City of Albuquerque

RE: LOT 22, BLOCK 20, EAST CENTRAL (339 Muriel NE) (K21-D31). GRADING AND DRAINAGE PLAN FOR BUILDING PERMIT APPROVAL. ENGINEER'S STAMP DATED MAY 12, 2000.

Re: T.C.L. submittal for building permit approval for Storage/Garage Building,,
339 Muriel St. N.E., East Central Business Subdivision, Block 20, Lot 22. [G17/ D077],
Engineer's Stamp dated 5/12/2000.

DRAINAGE AND GRADING PLAN
FOR
LOT 22, BLOCK 20, EAST CENTRAL BUSINESS

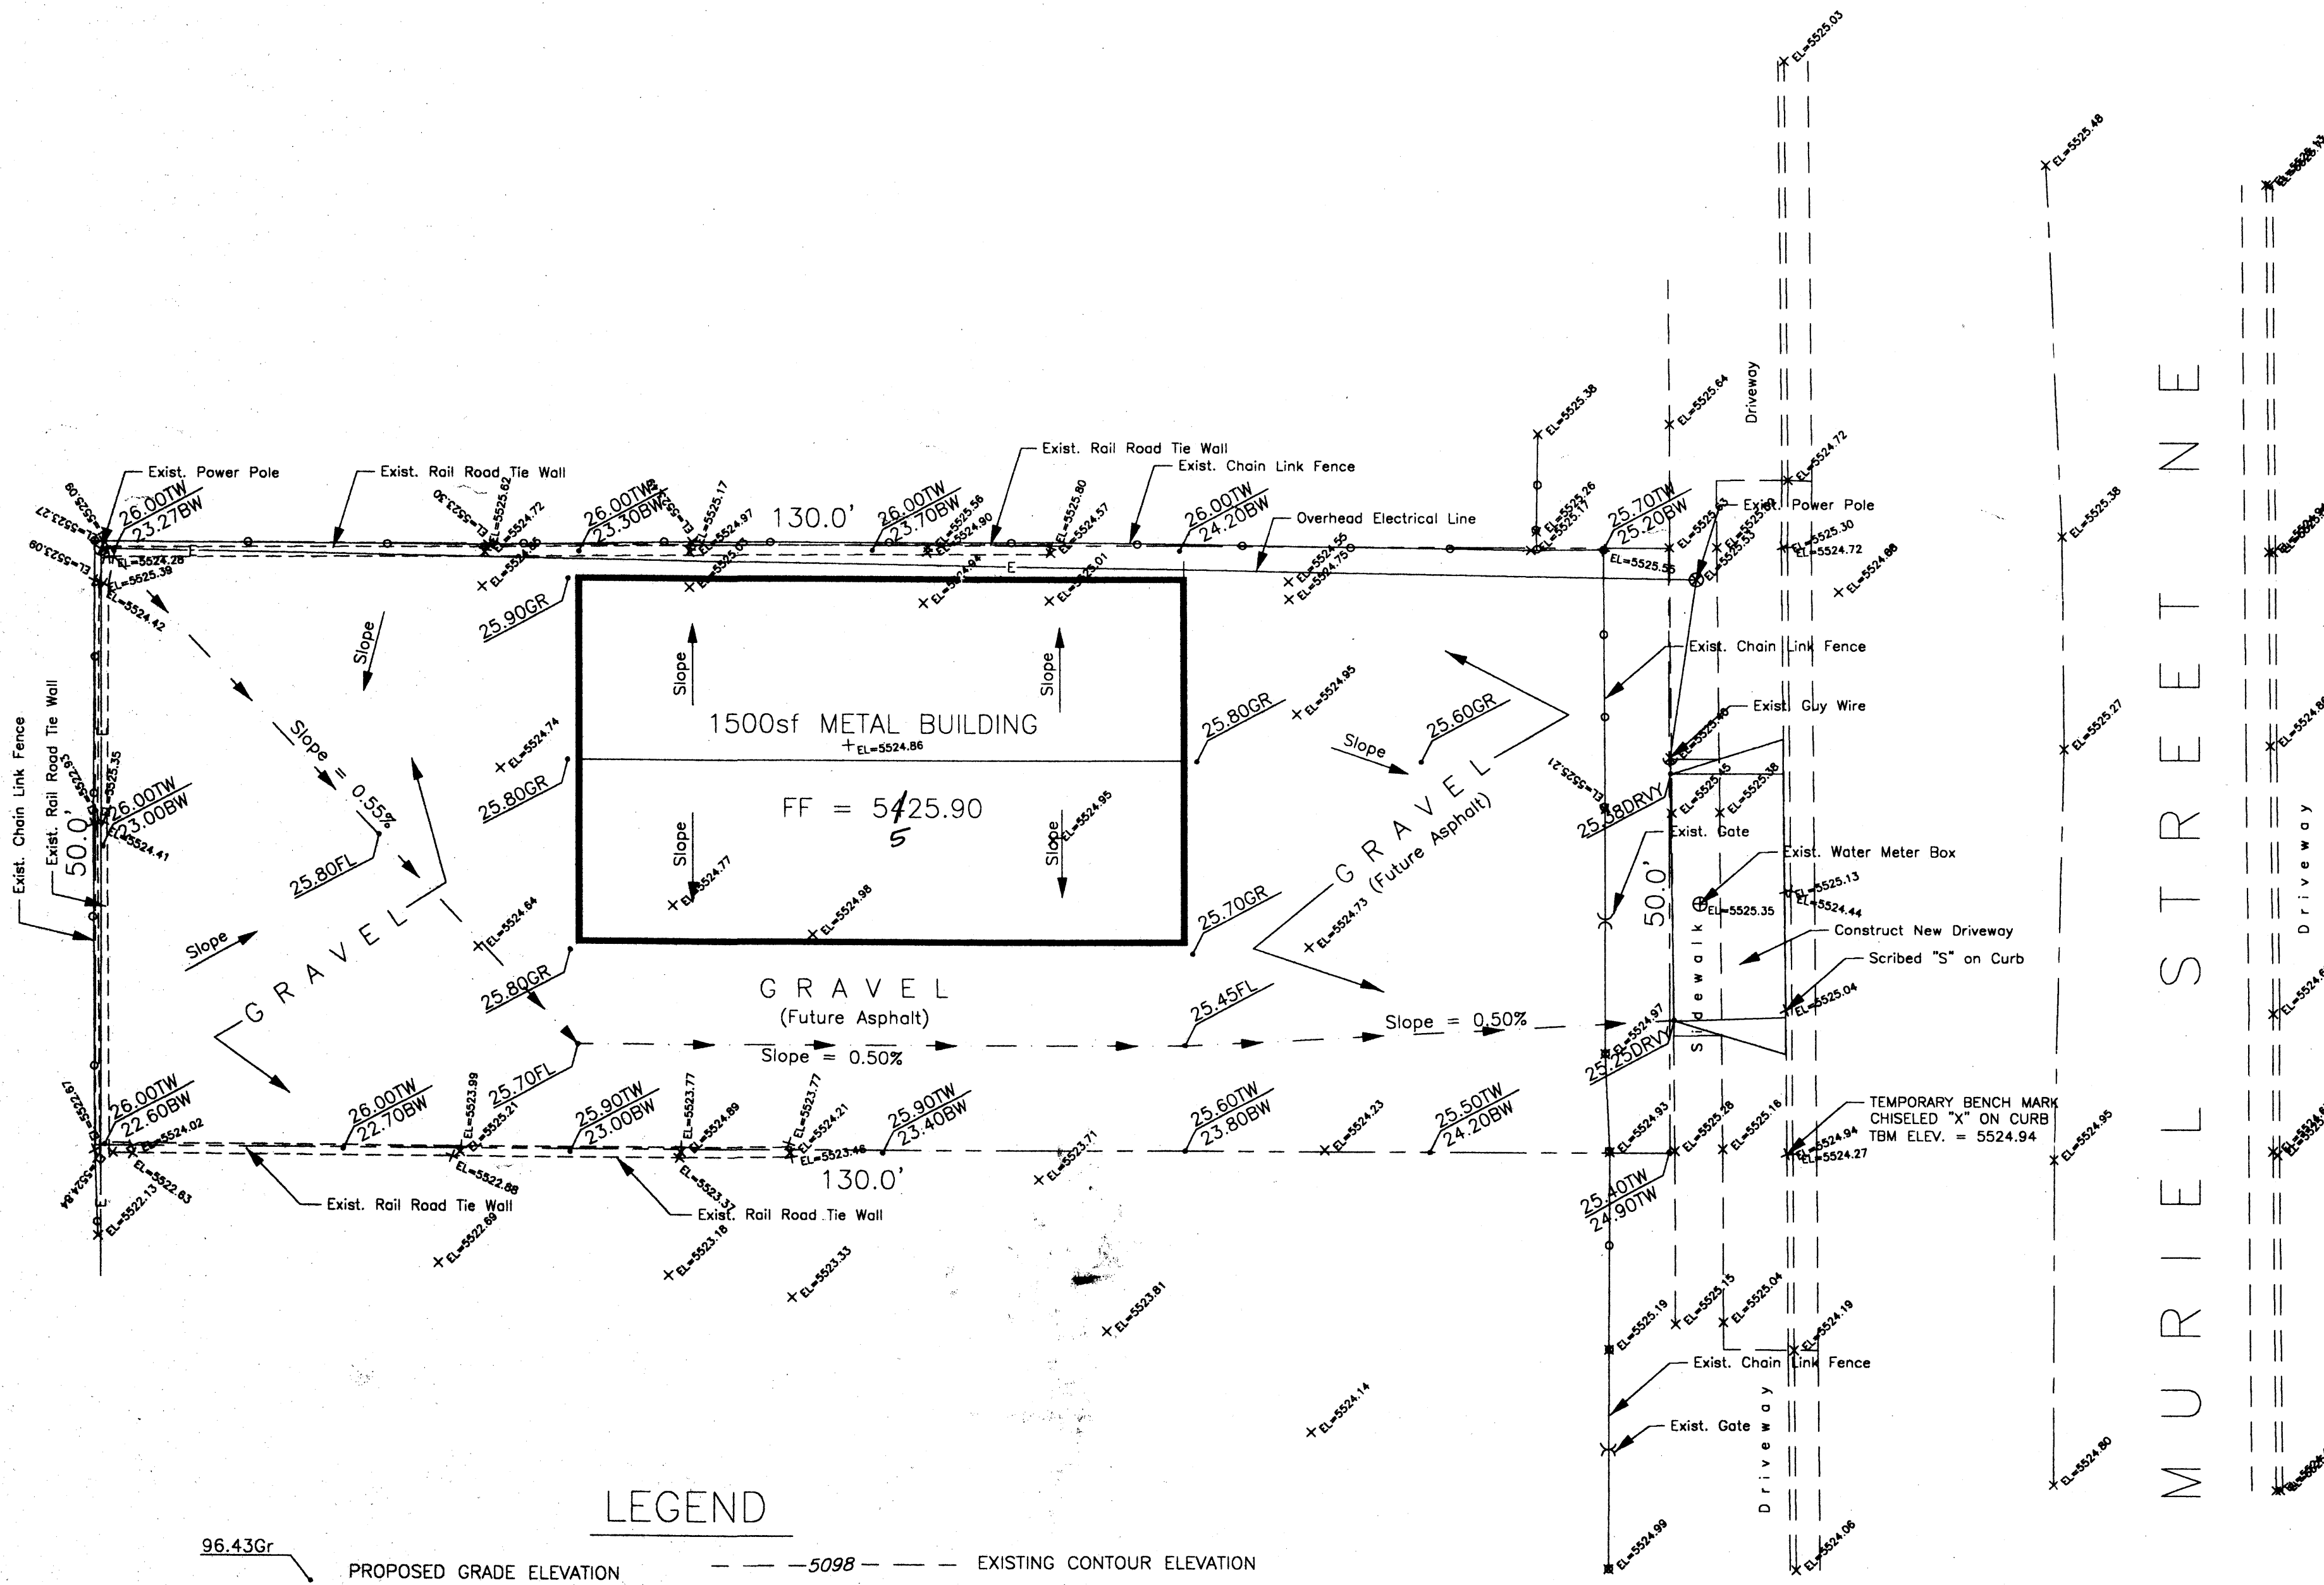
Please attach a copy of this approved plan to the construction sets prior to sign-off by Hydrology. Note that finish floor elevation is 5525.90 not 5425.90 as shown on this sbmittal.
